WELWYN HATFIELD COUNCIL – DEVELOPMENT CONTROL
DELEGATED REPORT

APPLICATION No:	S6/2009/2354/FP
------------------------	------------------------

The proposed development would comprise a first floor rear extension over an existing ground floor lounge area. The extension would have one window to the rear.

| Rev. | Amendments | Date |
|--|------------|------|
| GENERAL ARRANGEMENTS FLOOR PLANS AND ELEVATIONS AS PROPOSED | | |

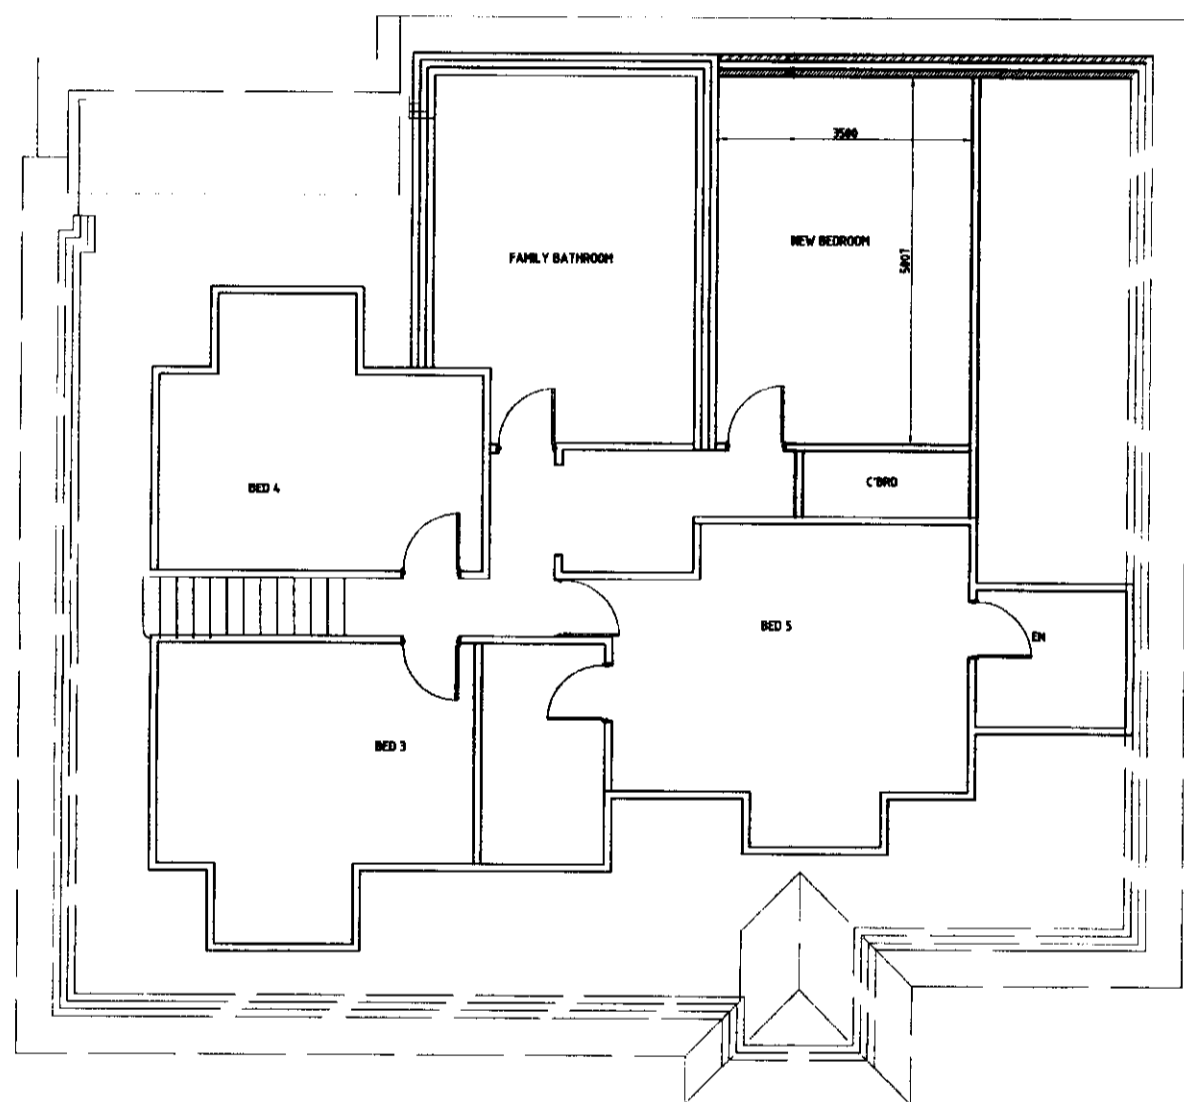
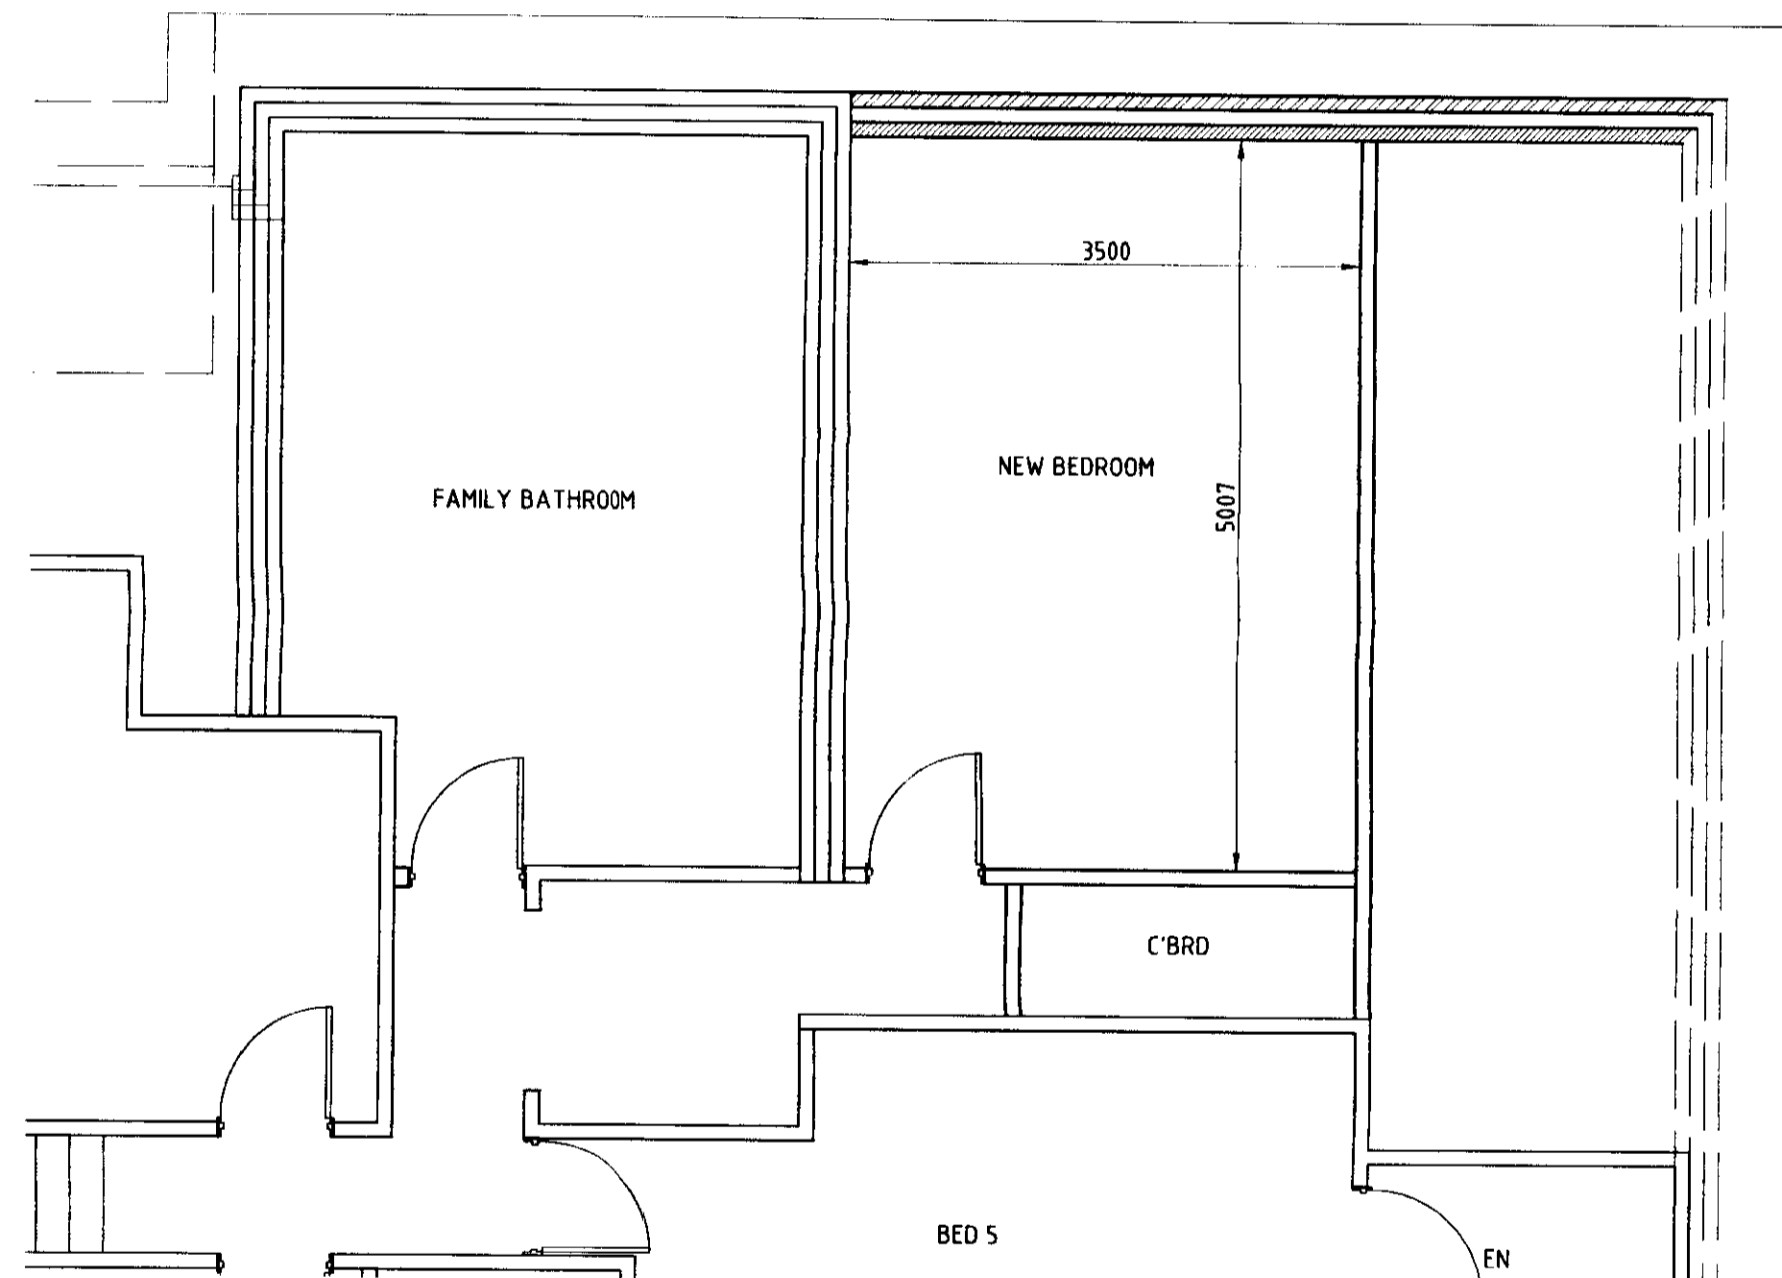
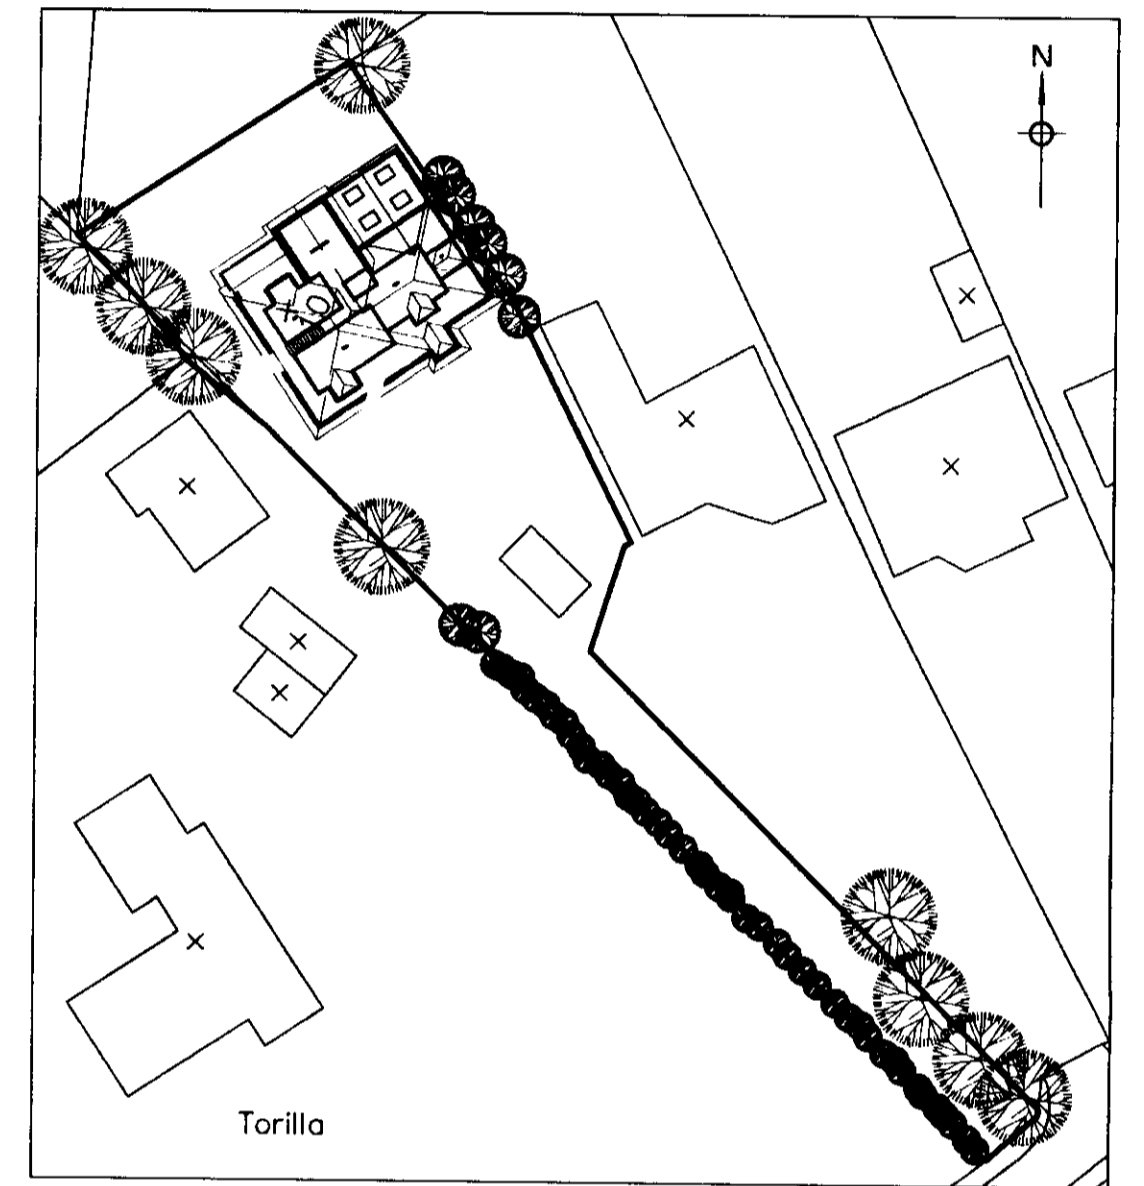
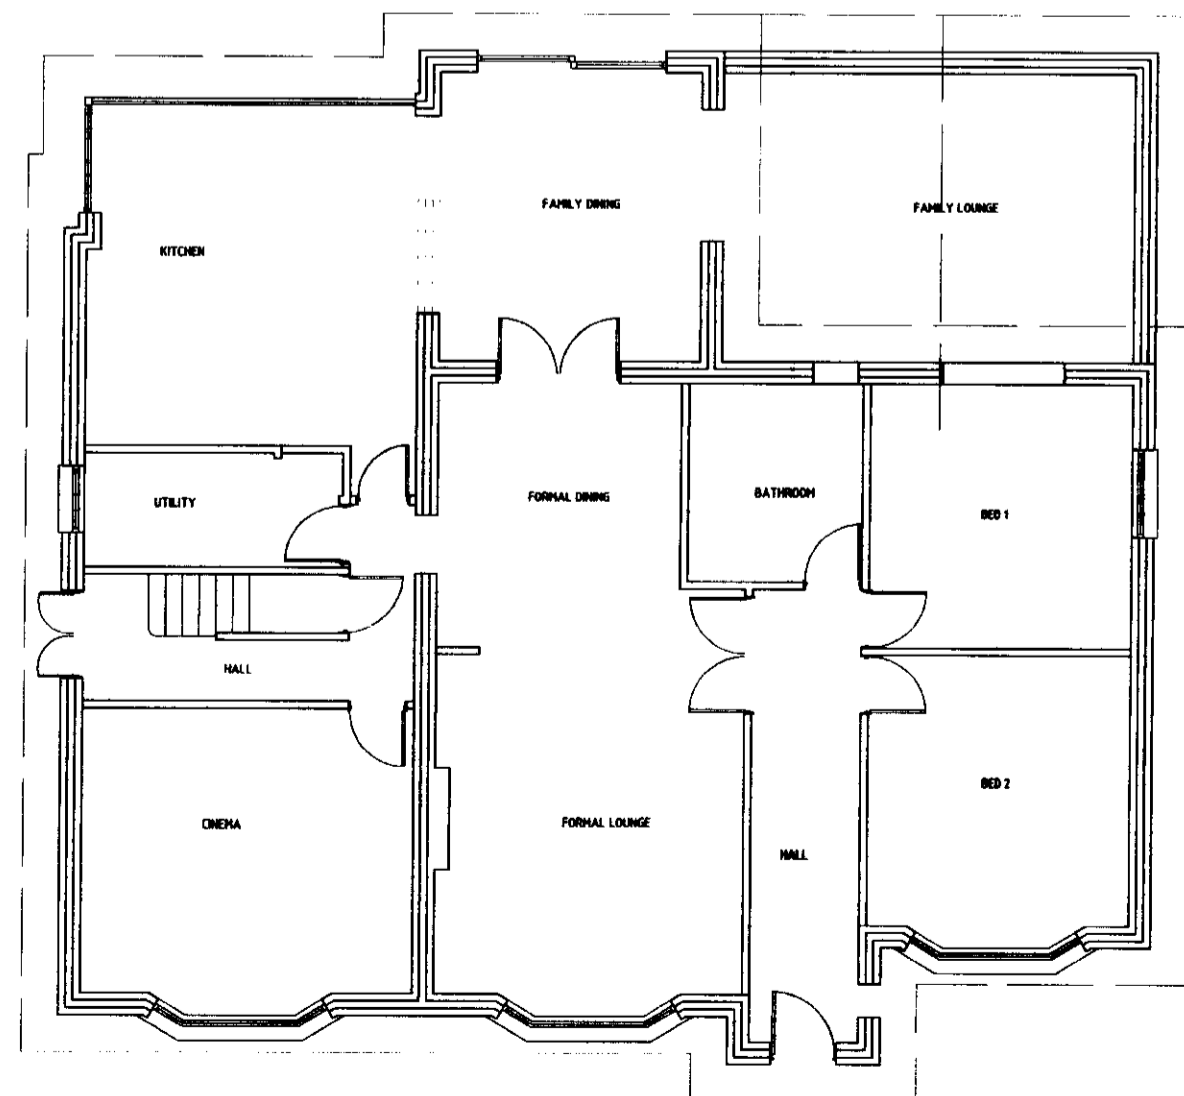
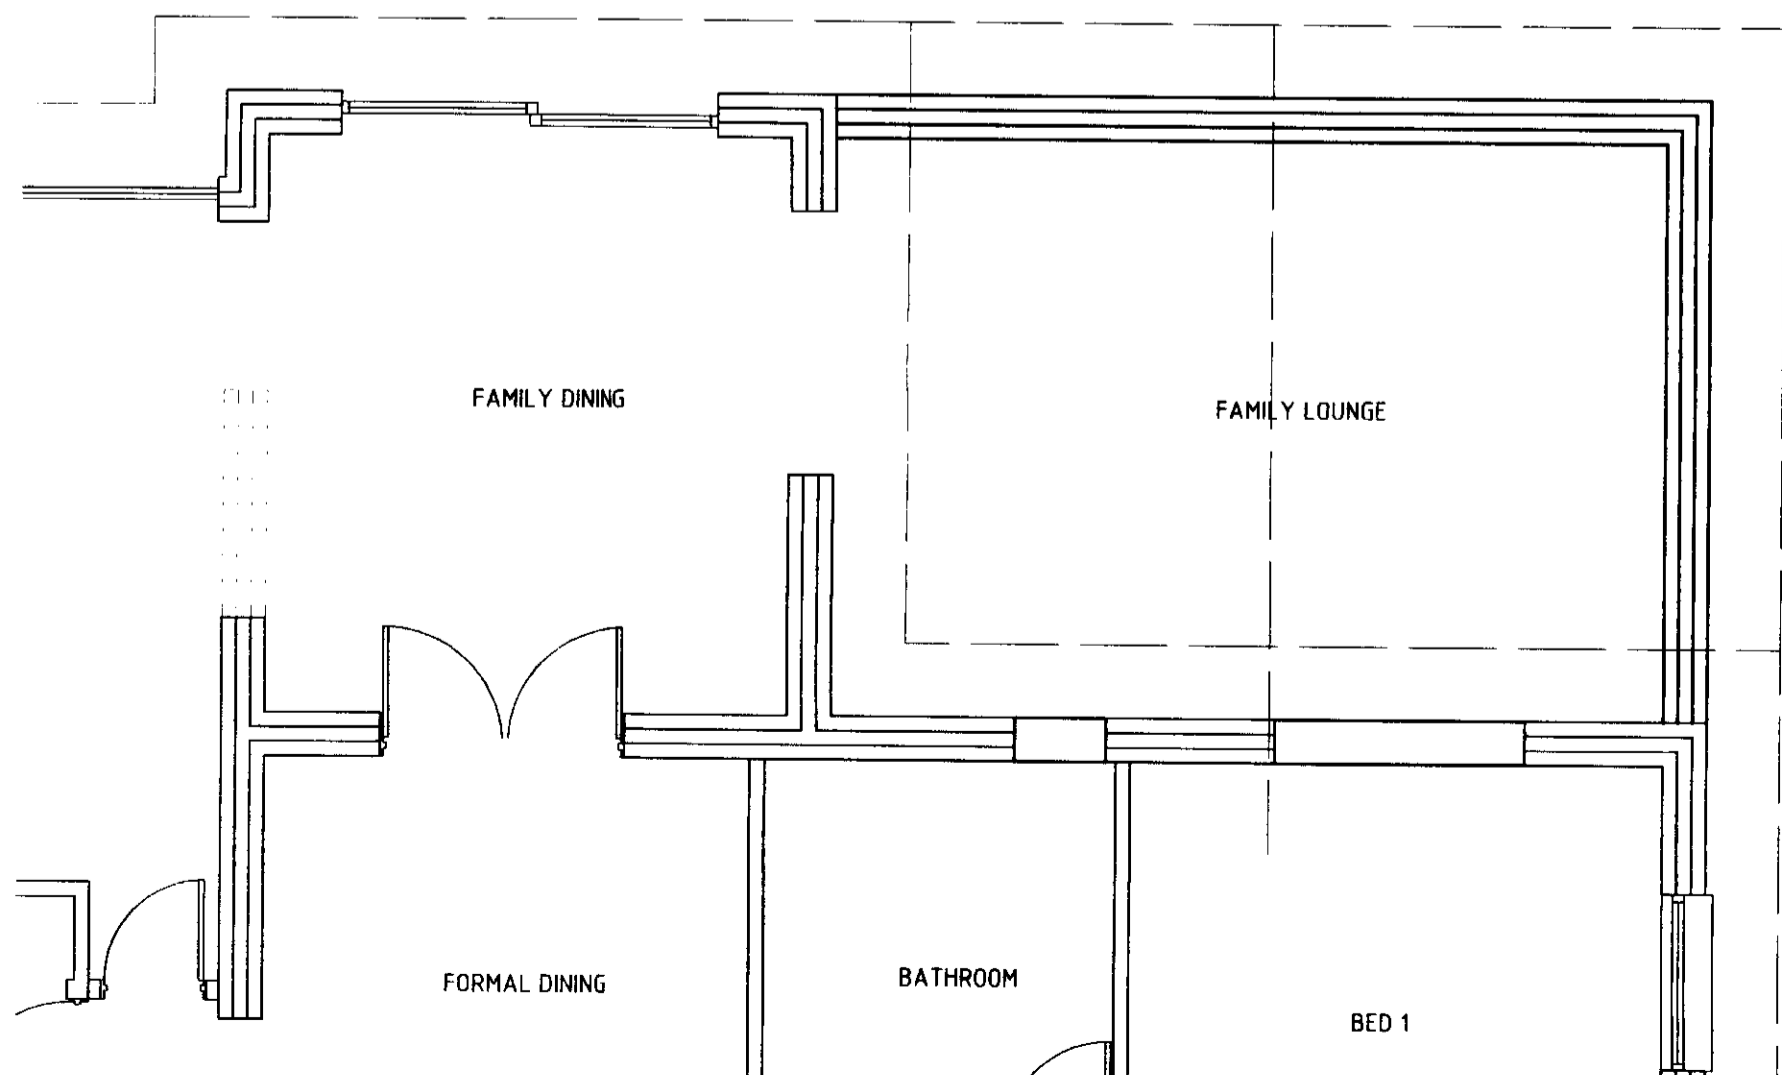
The proposed first floor extension would be glimpsed from the neighbouring properties, but would not appear prominent and would not have an adverse impact upon the character and appearance of the locality.

This latest extension and previous ones have given the dwelling a variety of roof slopes and features. The proposal would be at first floor level storey and would be

have a gable end style roof detail which was approved under the earlier in 2009. This design is considered to be in keeping with the character of the existing dwelling.

The proposal would only have one window which is to the rear elevation and this would not result in any significant overlooking or a loss of privacy to any of the neighbouring properties.
